From: Paul Moisan [REDACTED]
Sent: 24 March 2020 15:04
To: James Cross <James.Cross@arun.gov.uk>
Subject: 5542 L.P UoC BR/352/19/PL & BR/351/19/L - Upper Bognor Road, Bognor Regis
Importance: High

Drawing
71 Upper Bognor Road
Ground Floor as existing

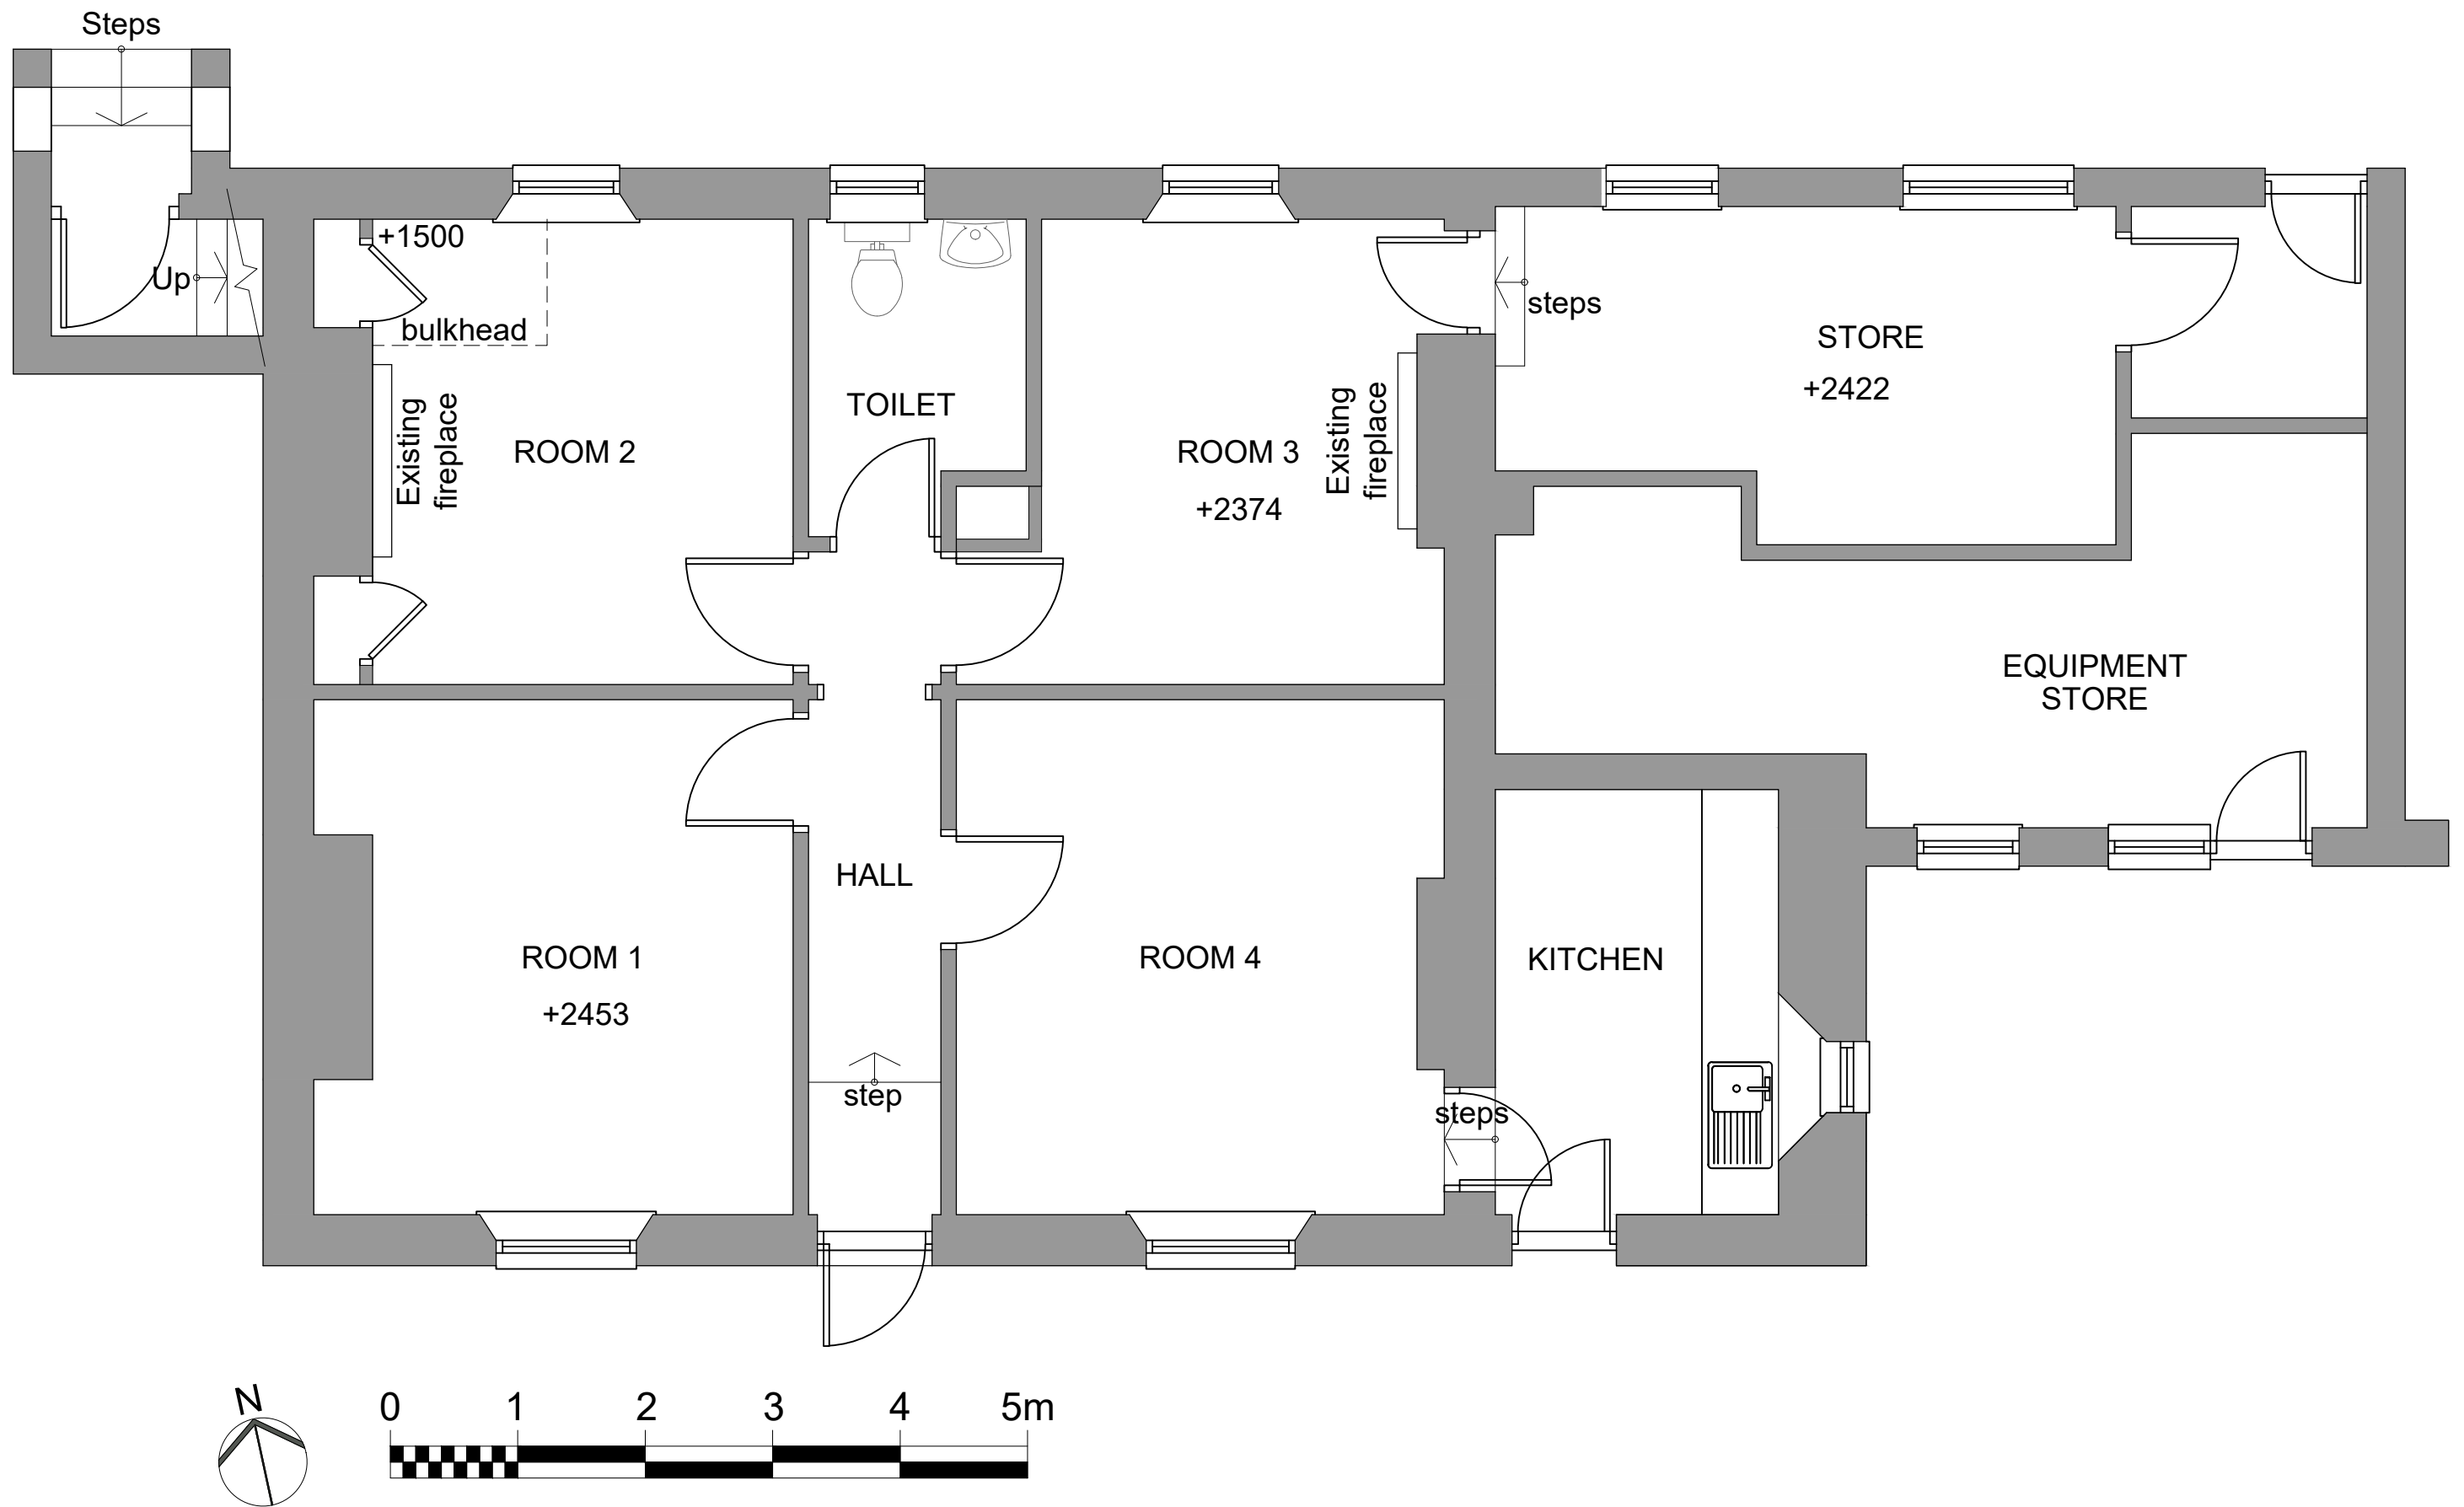
No 71 is to be converted back to residential accommodation from offices. Being on the ground floor it is not above 4.53m AOD and so as per clause 7.2.3 of the FRA needs to be subject to a 'flood resilient' approach.

With regard to the increased risk to No 71, temporary flood barriers could be erected all around this property in the unlikely event of an anticipated undefended tidal flood.
